From: Caroline Ford
Sent: 28 August 2019 10:03
To: DC Support
Subject: FW: 19/00248/DISC Holiday Inn Express
Attachments: Evidence 5 A103271-1 Bicester Hotel HLMP 16-08-2019.pdf

I don't think I have received comments from you on the above DISC yet – it is actually due a decision tomorrow so if you have any comments, please can I have them as soon as possible? It is a Habitat and Landscape Management Plan and it has been amended in response to Charlotte Watkins comments (as below). The amended version of the document is attached.

19/00248/DISC Holiday Inn Express, Bicester Gateway Business Park

Scale at A3: 1:800	Project No: A103271-1	Drawing No: Figure 3	Revision: B
Drawn by: Maddie Errington		Drawn date: 16/08/2019	Approved by: Tom McClellan-West

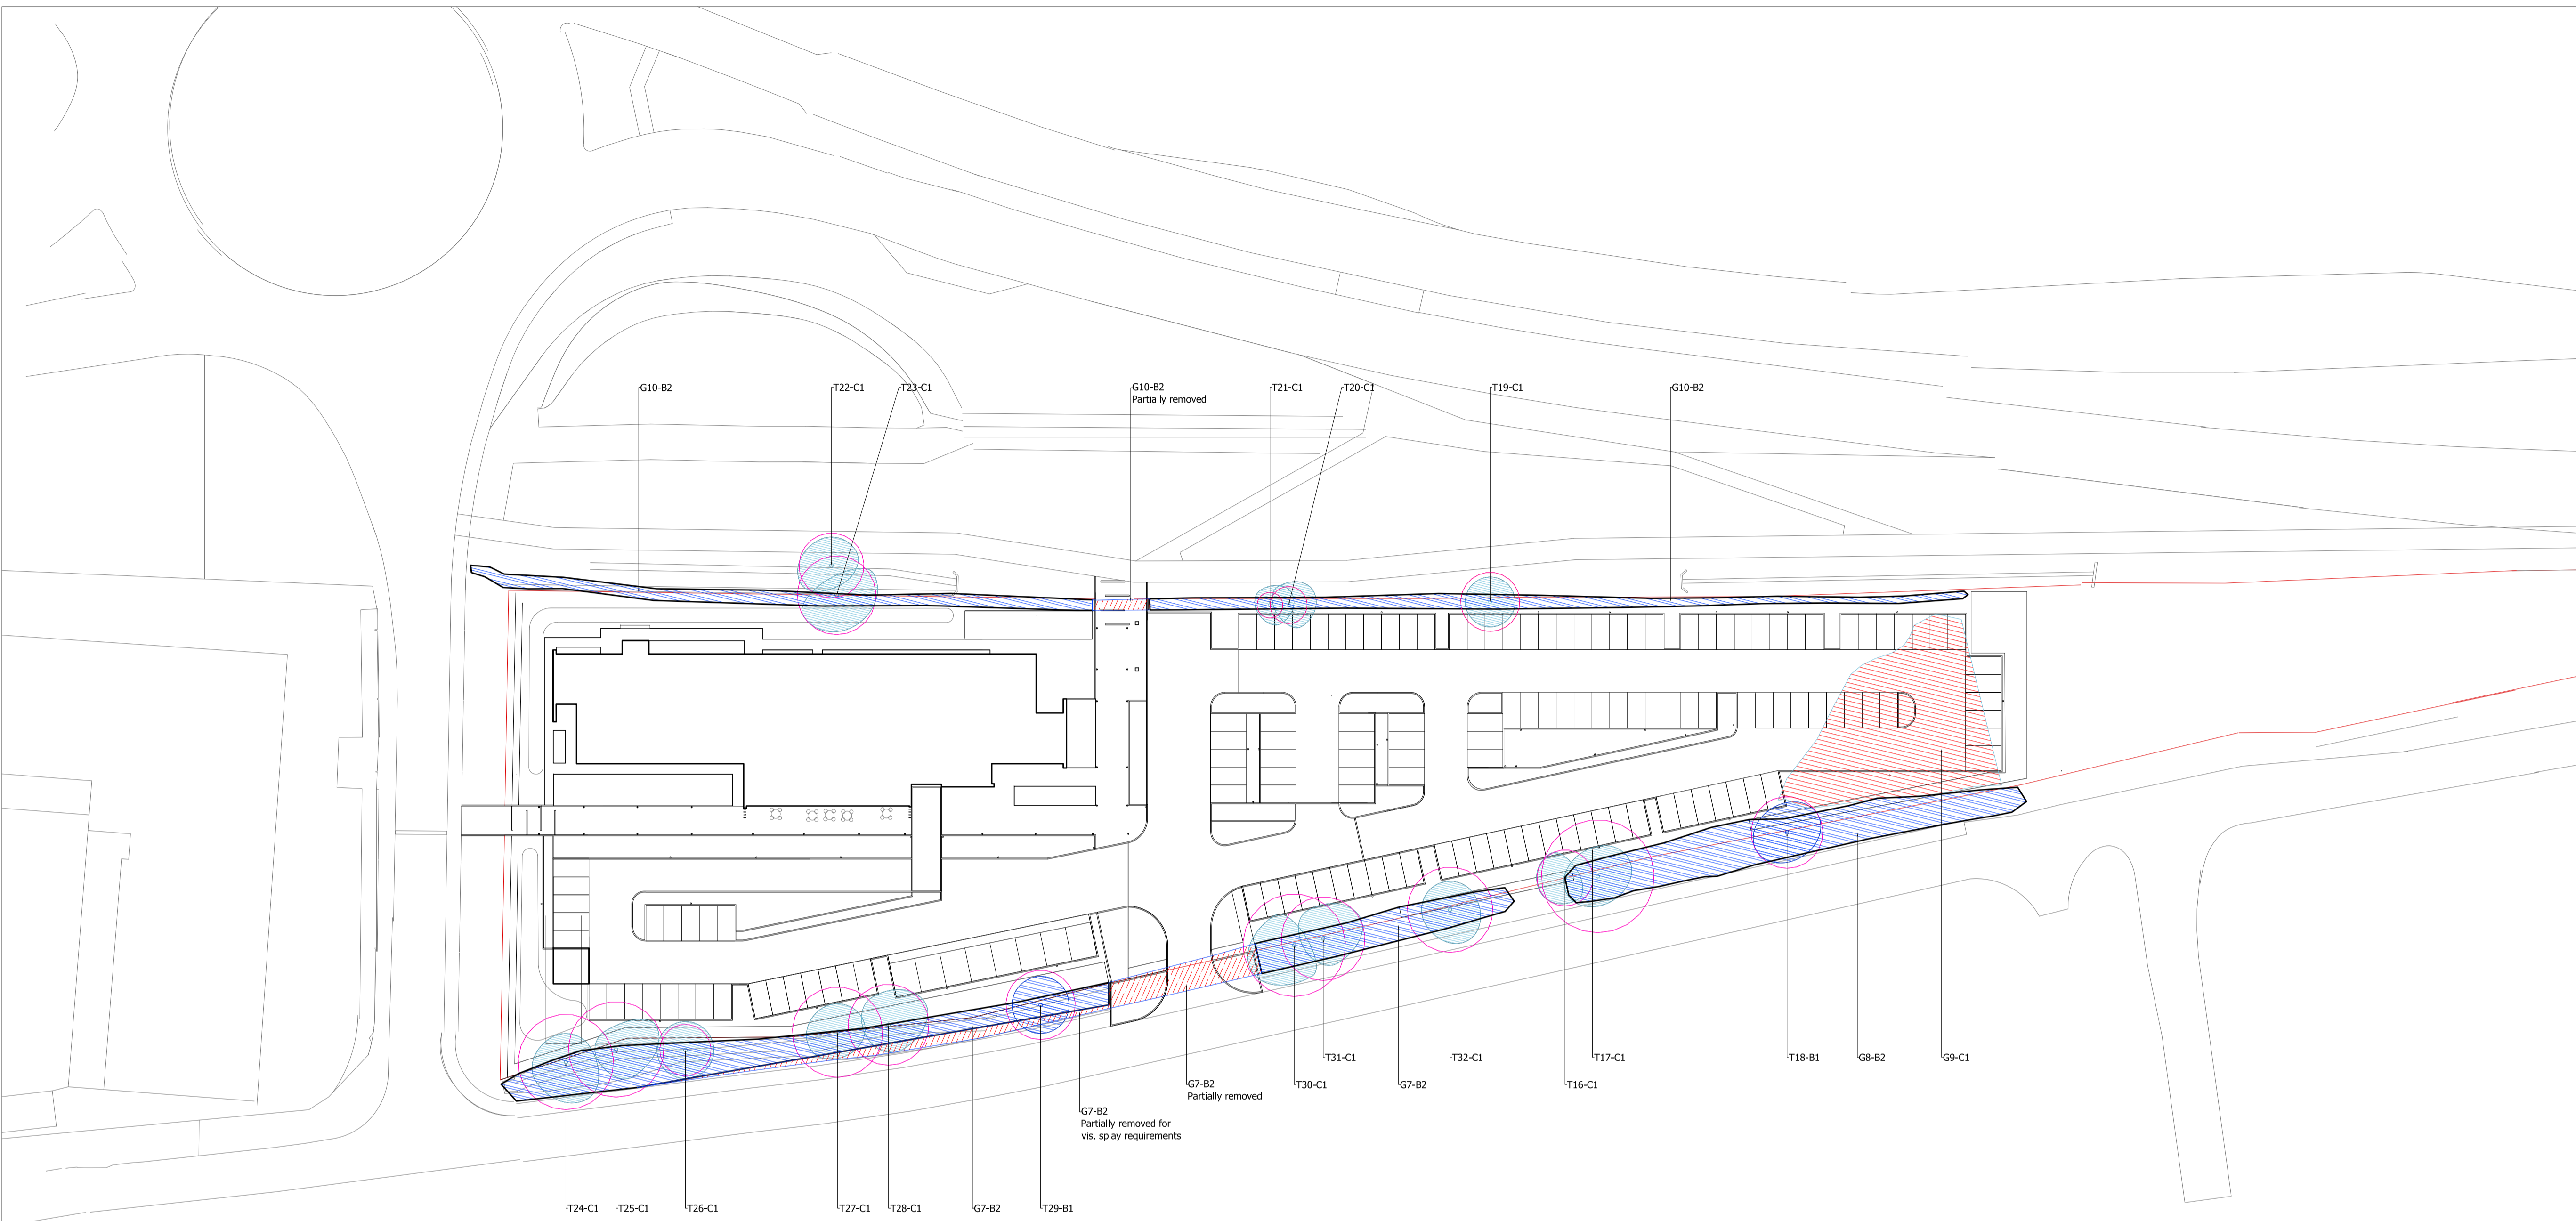
Please ask WYG to include maintaining bark mulch to 50 mm depth around all new trees, hedgerows and shrubs and herbaceous planting.

Include localised weed control around new trees.

I have read through the Habitat Management Plan and I have no major issues with it. My only suggestions would be that they should move the Southern Aspect triple swift box to a slightly different aspect (any with relatively clear flight lines) - South facing boxes are not ideal as they can get too hot. If this is amended then I would be happy for conditions 4 and 12 to be discharged on the basis of this document.
